Examiner's Second Written Questions

ExQ	Question to:	Question:	National Grid Gas Response:
Q1.1	The Applicant and National Grid Gas	Please provide an update on the outstanding matters in the SoCG.	With regards to the outstanding issues raised in the SoCG published at Deadline 2, the parties continue to discuss the protective provisions but agreement on the drafting has not yet been reached. Discussions have progressed since the SoCG was published and the majority of National Grid's concerns have been addressed. The parties will continue to work together to resolve the outstanding issues.
Q8.6	EA, UKHSA, Health and Safety Executive, National Grid, Western Power Distribution	<p>Please comment on the matters raised in AW's D4 submissions [REP4-013 and REP4-014] and questions Q8.1 to Q8.4 above insofar as they affect your areas of responsibility:</p> <p>Q8.1 – to the Applicant</p> <p>What provisions have been made to ensure the integrity and longevity of the Anglian Water (AW) pipelines during the construction and operational phases and following restoration? In your response, please address the issues of bank stability, hydrogeology, ingress of potential contaminants into the pipelin

DRAWING 1621.SWM.14

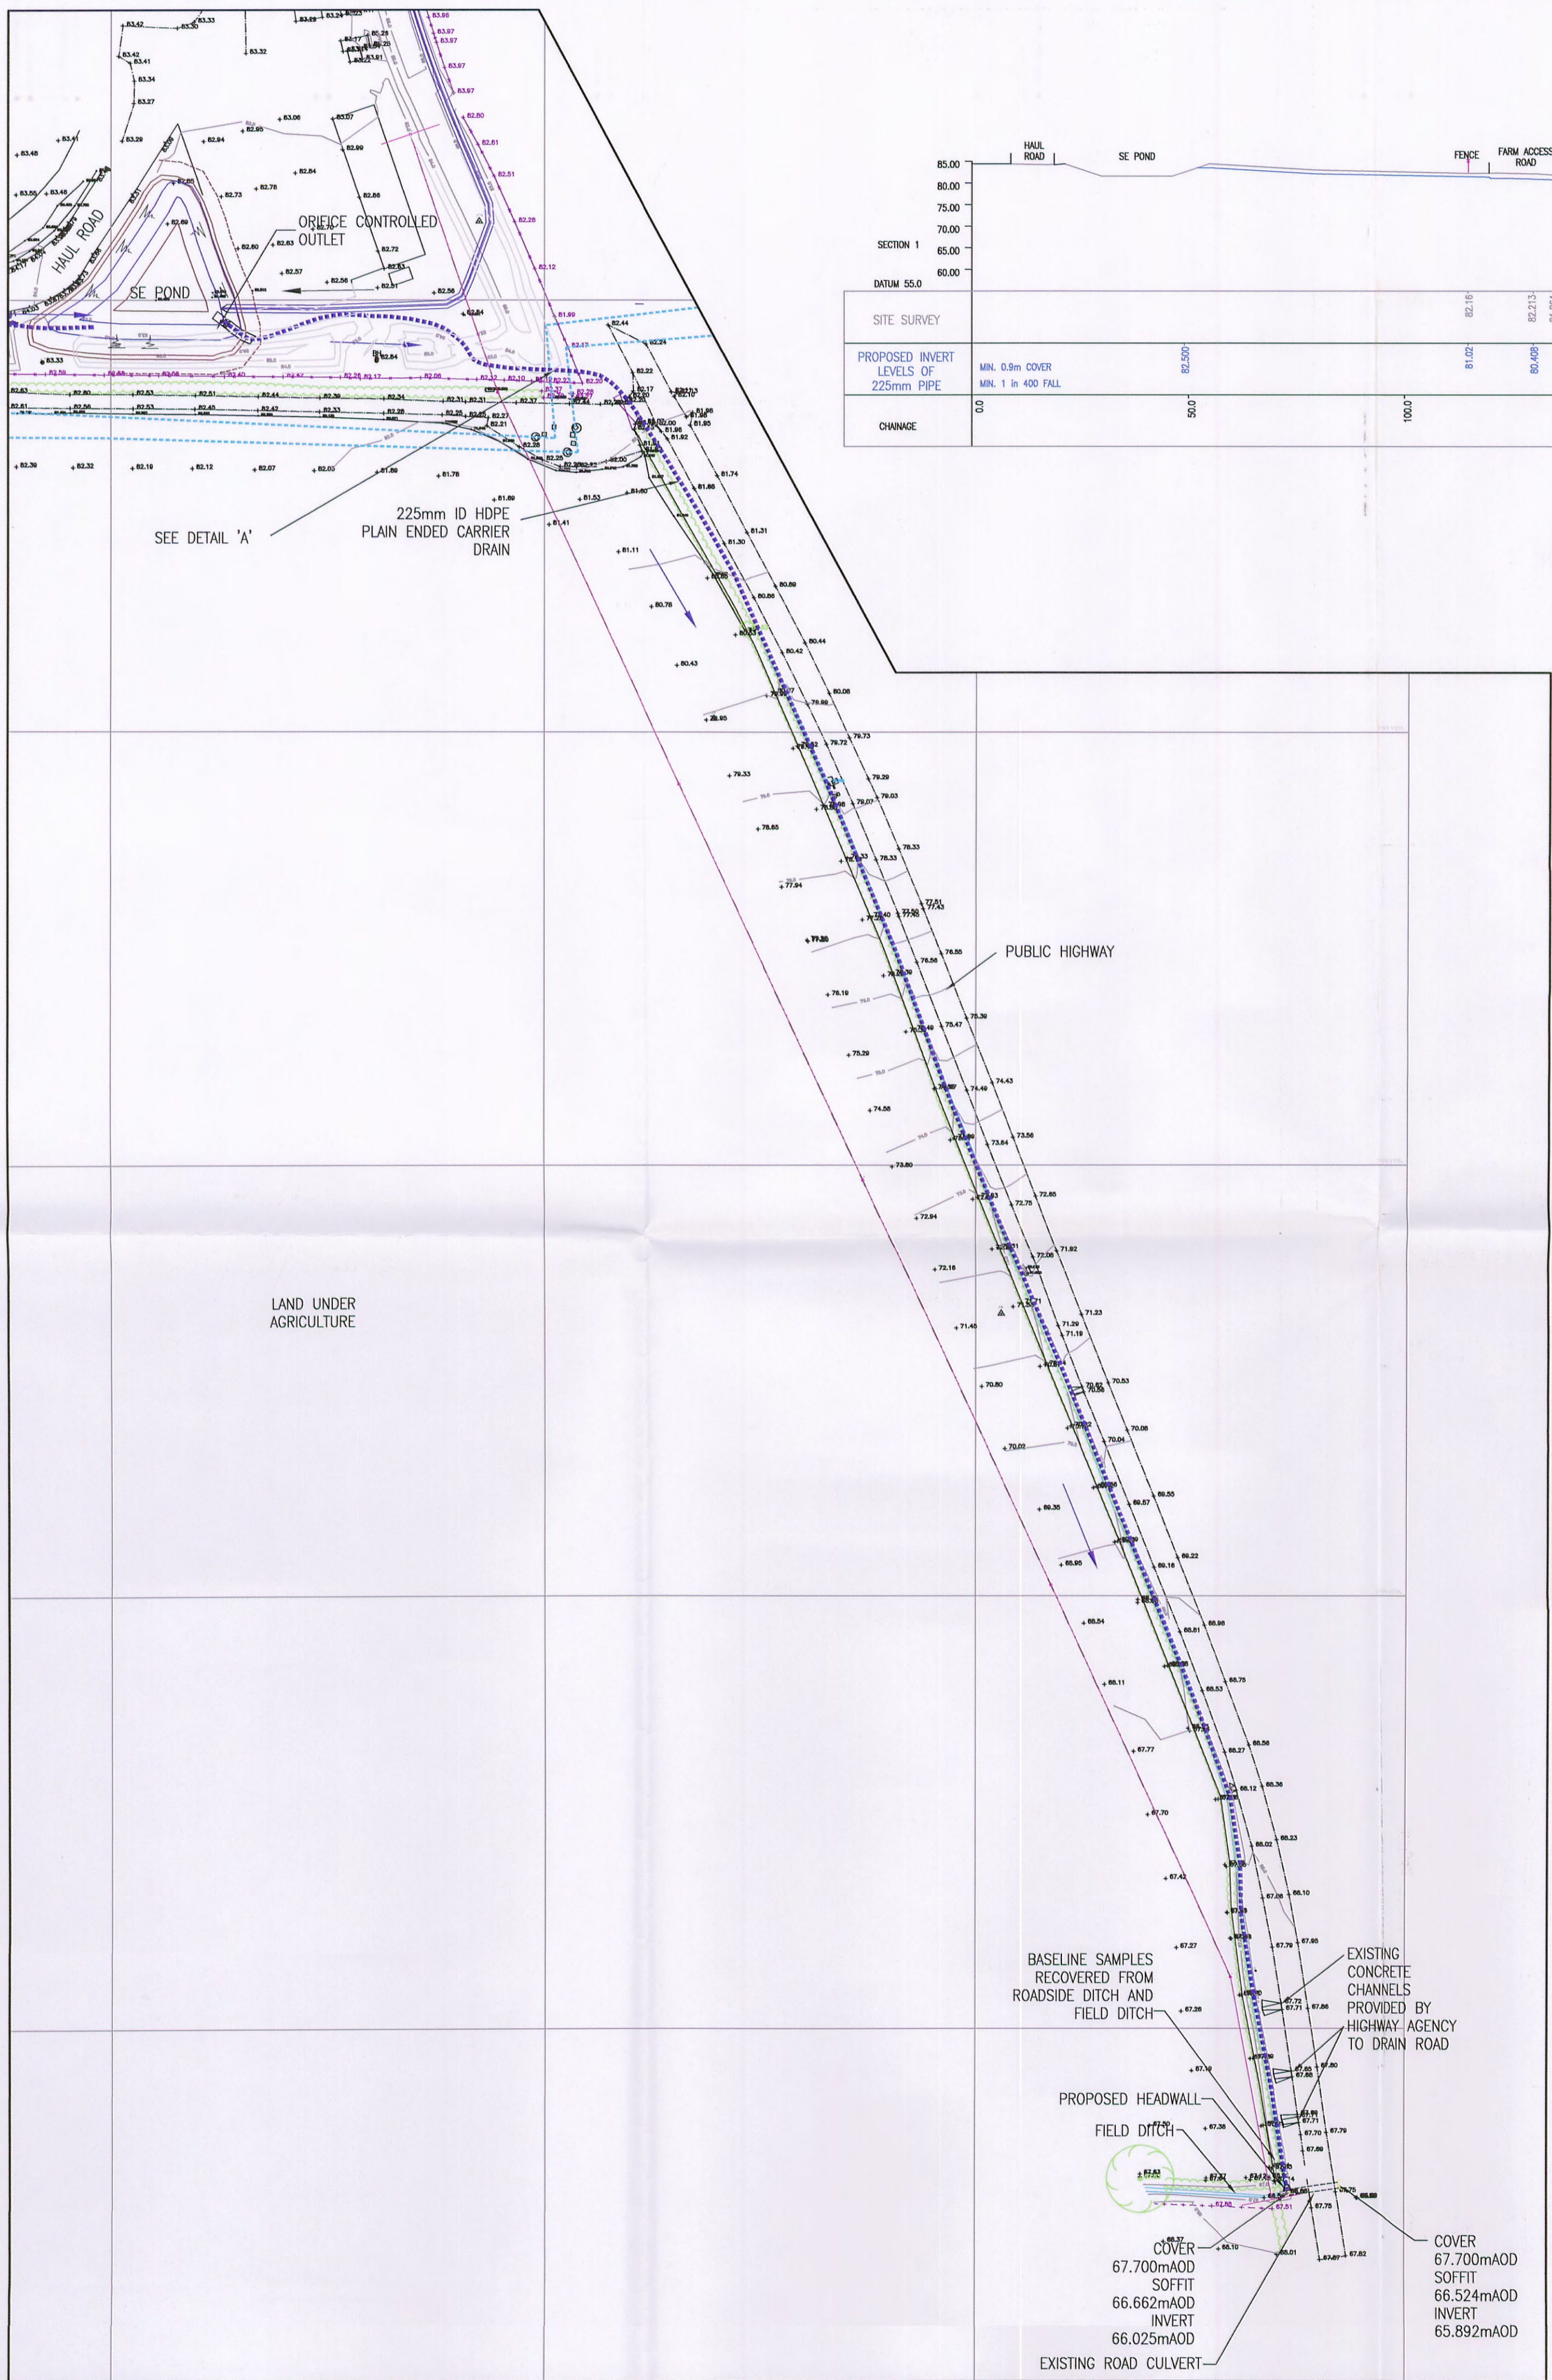
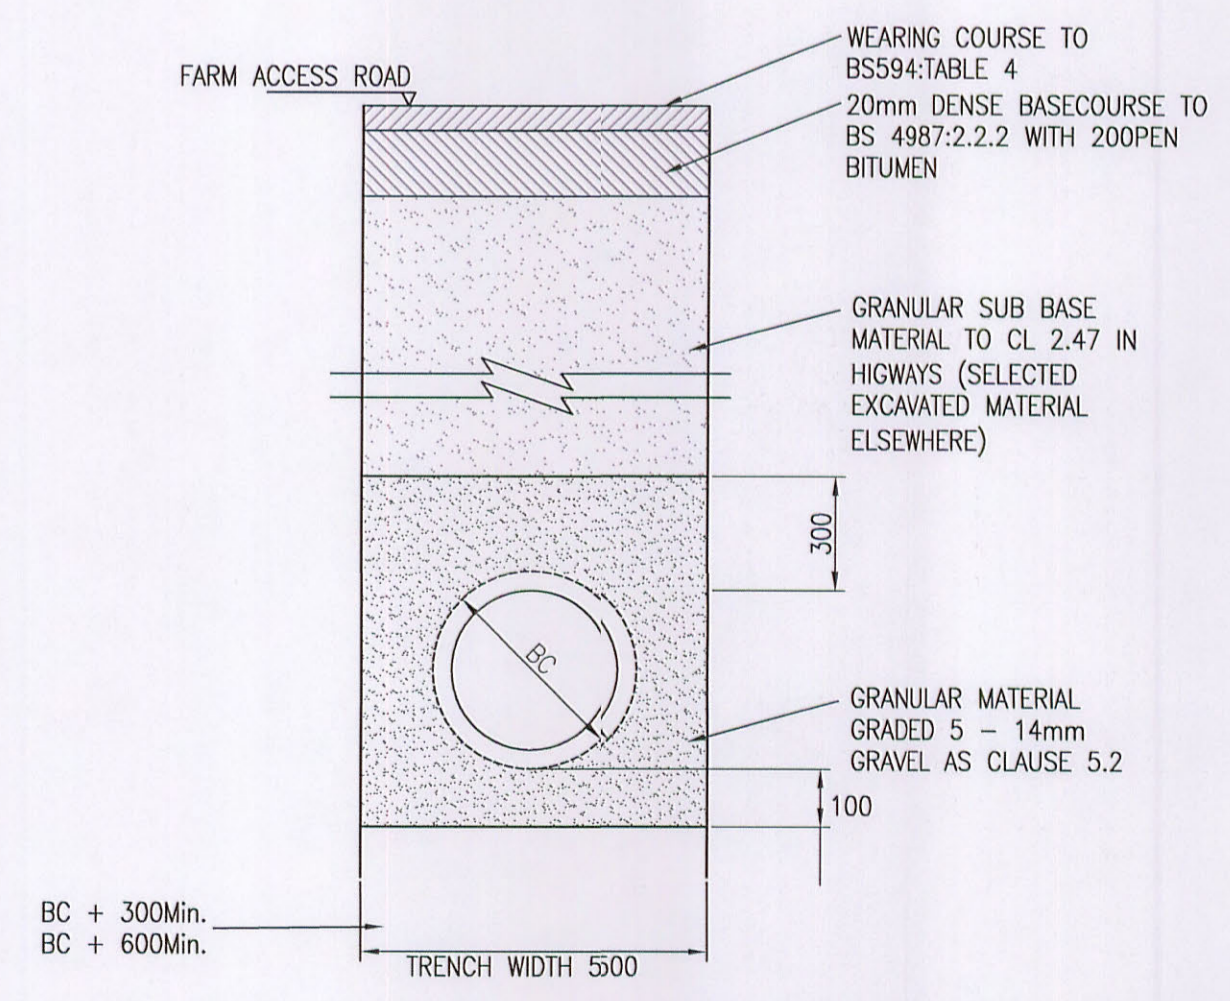
<p>Please comment on the concerns of AW [REP4-013 and REP4-014] regarding the effect of the Proposed Development on its pipelines with regard to:</p> <ul style="list-style-type: none"> a) the integrity and longevity of the pipelines; b) the potential for contamination of the water supply due to the presence of LLW; c) the potential for contamination of the water supply in the event of a failure of an AW pipeline; d) the potential for contamination of the site and surrounding area in the event of a failure of an AW pipeline due to the mobilization of LLW and other contaminants; e) the effect on other utilities infrastructure, including the proposed undergrounded electricity line and the high-pressure gas pipeline, in the event of a failure of an AW pipeline. <p>Q8.4 – to AW</p> <p>Please expand on the concerns set out in AW's D4 submissions [REP4-013 and REP4-014] with particular regard to:</p> <ul style="list-style-type: none"> a) quantification of the increased risk of failure of an AW pipeline as a result of the Proposed Development; b) the options for avoiding/mitigating the increased risk of failure of the pipeline (for example, routes for diverting the pipelines or, if the pipelines were retained in their current positions, increased stand-off distances and/or enhanced protective 	<p>be affected by a failure of the AW Pipeline is dependent on the circumstances of the failure and factors such as local soil conditions, extent of debris, attributes of the AW Pipeline (diameter, material, operating pressure, etc.), direction of the leak/failure and extent of pooling and volume of water.</p> <p>National Grid notes that the impact of such a failure would be dealt with by way of the protective provisions being negotiated with the Applicant.</p>

<p>measures or changes to the design of the Proposed Development;</p> <p>c) provisions to allow satisfactory access to maintain and repair the pipelines.</p>	
--	--	---	--
